Richard Spencer
Morleys Croft
Binsted
Arundel
BN18 0LQ

Arun DC
Planning
Ref:- WA/63/16/PL Fairmeads Farm Binsted.

DRAWING Proposed new farm machinery
and equipment store

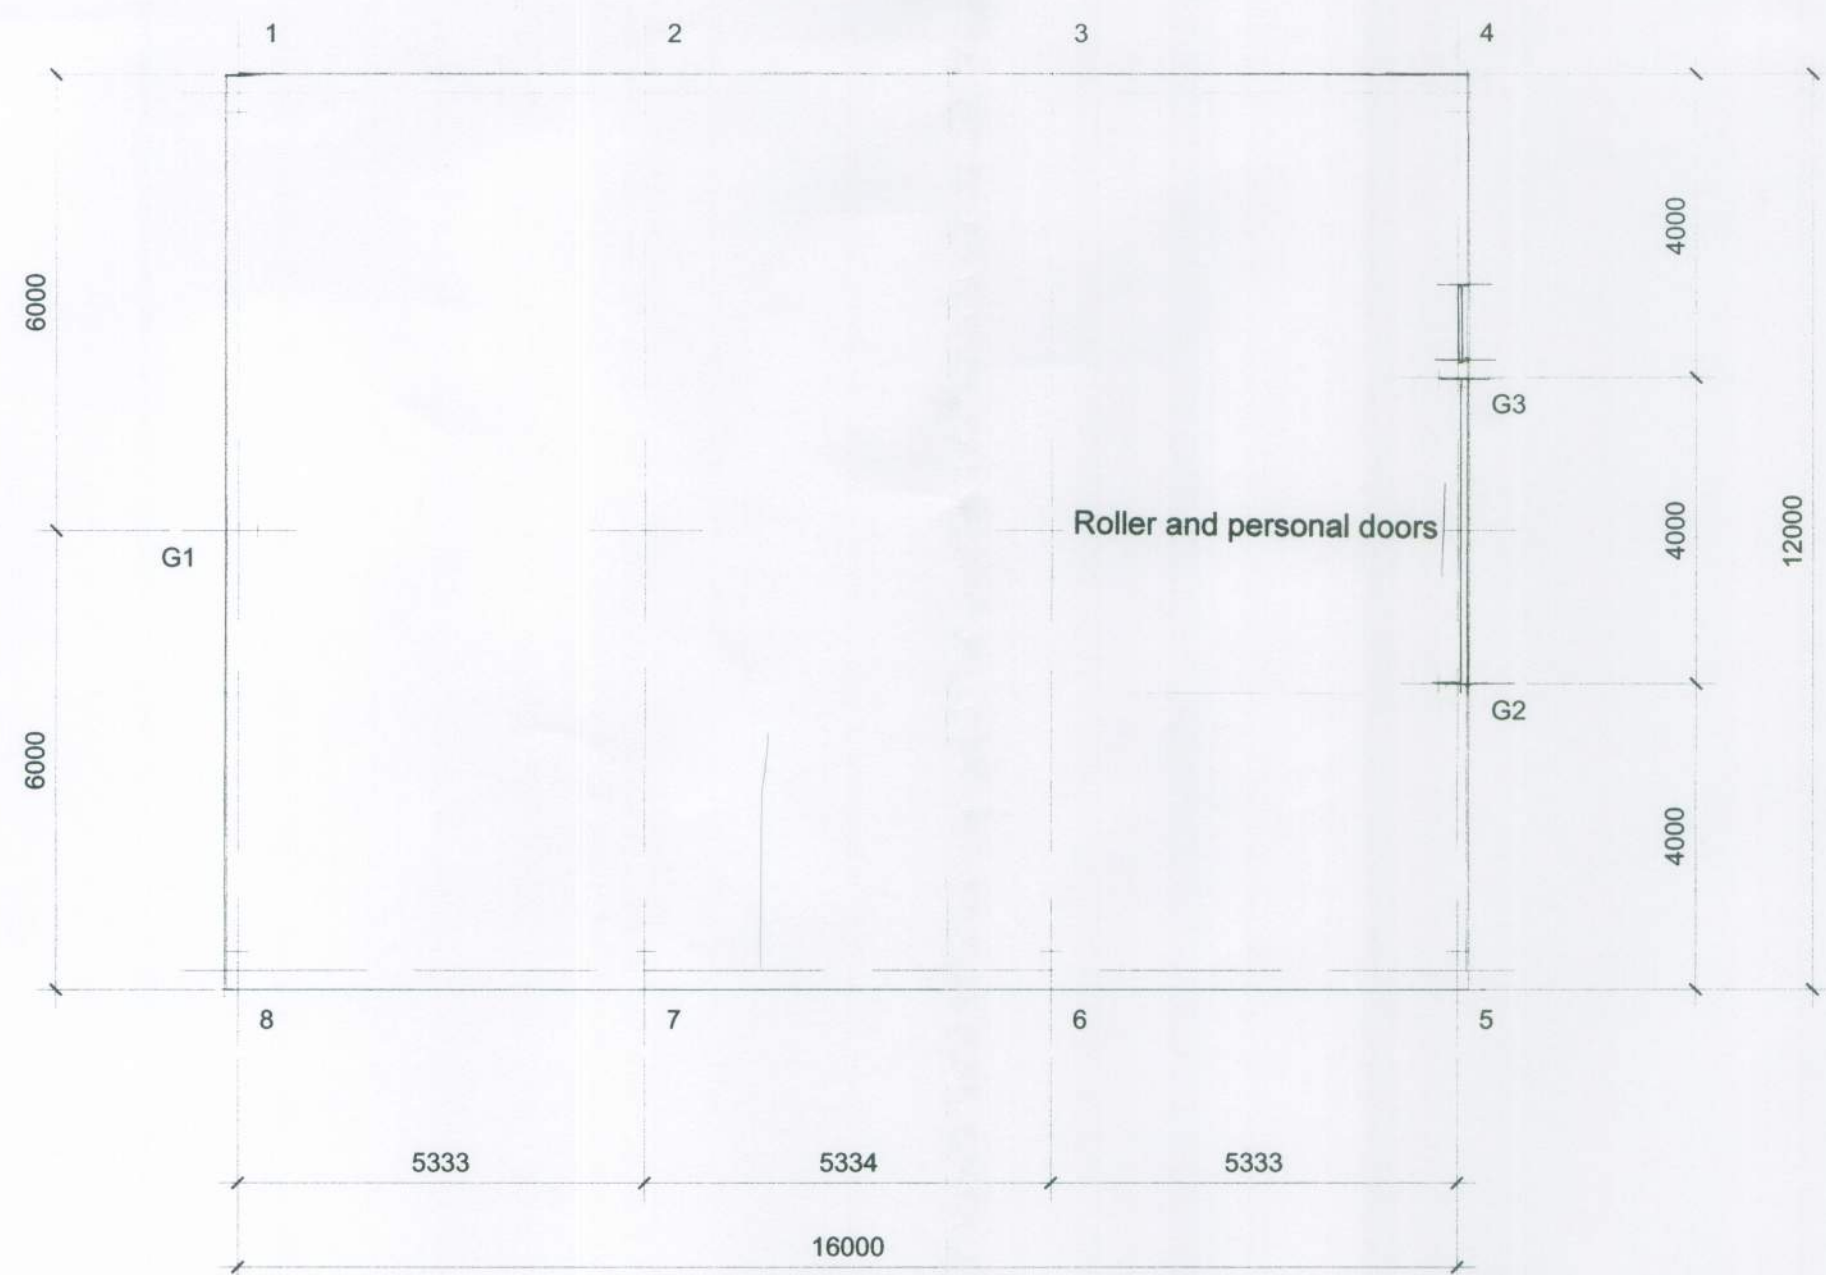
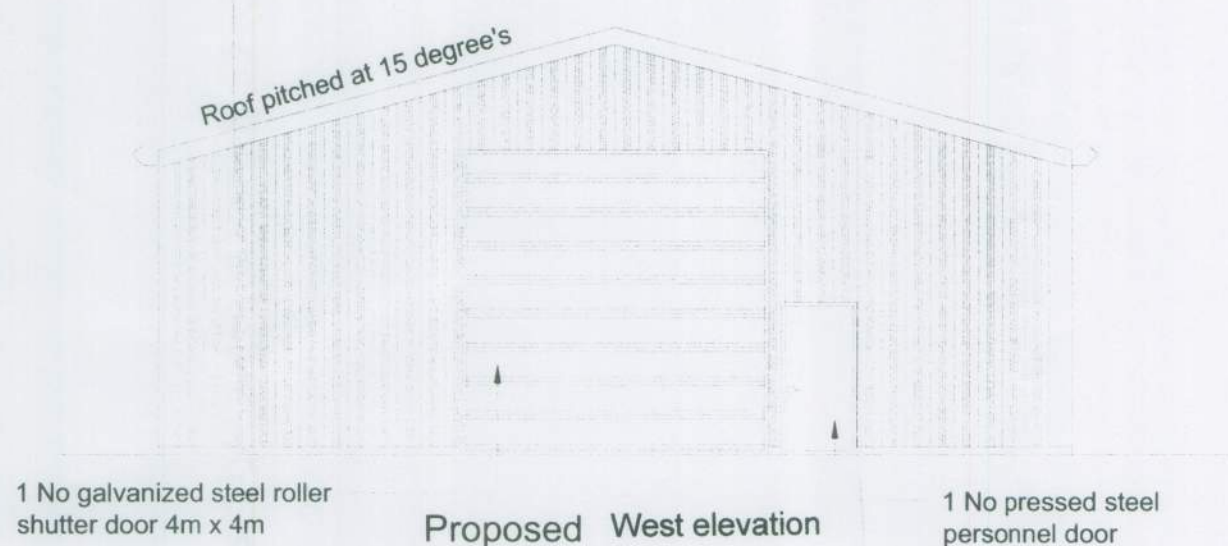
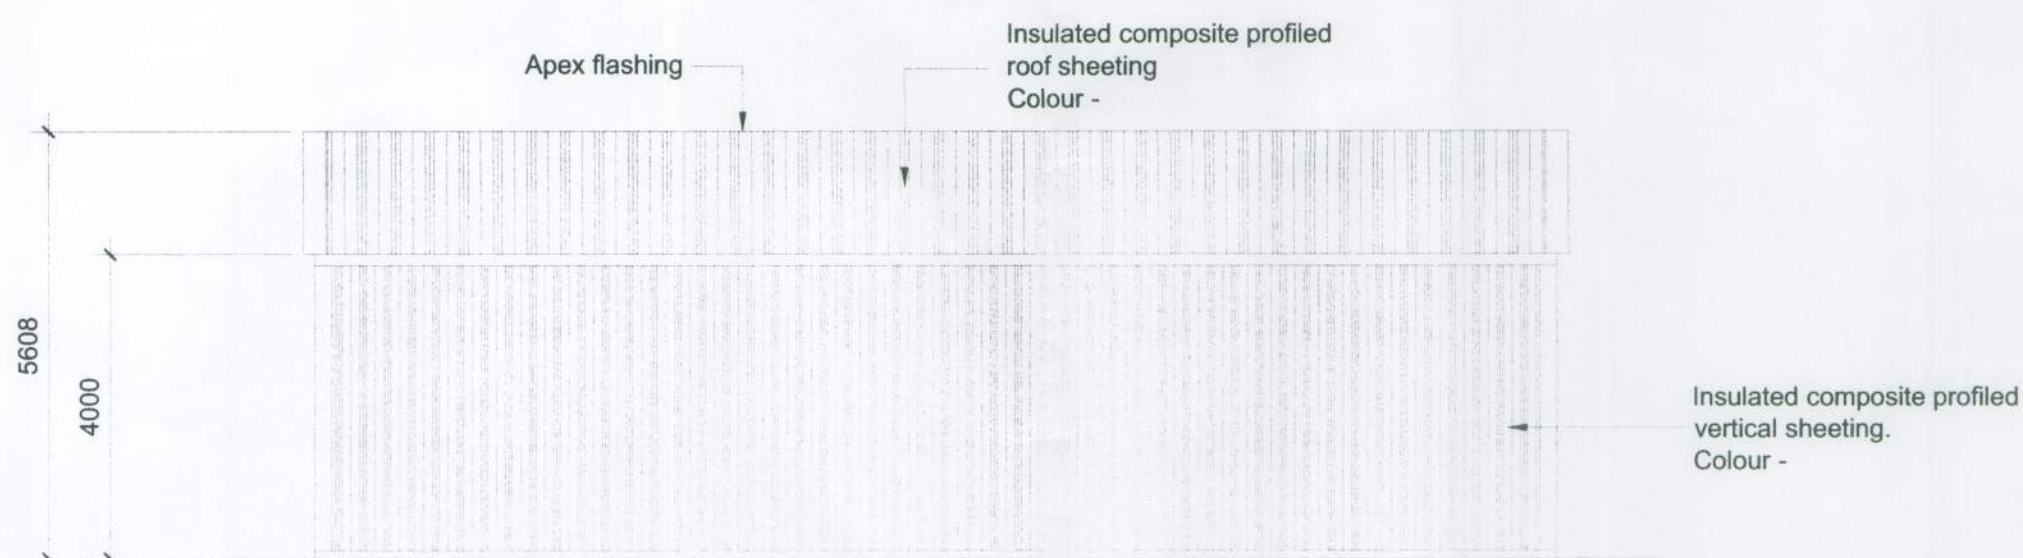
2. The visual impact of the proposed buildings will be severe. They are both large in particular Bldg 2. At a height of 7 metres and a length of 18 metres this will be seriously unsightly. These are not going to be elegant structures. They will be ugly industrial blocks. Quite how the applicants agent can say "the whole scheme is designed to enhance and improve..." is hard to grasp.
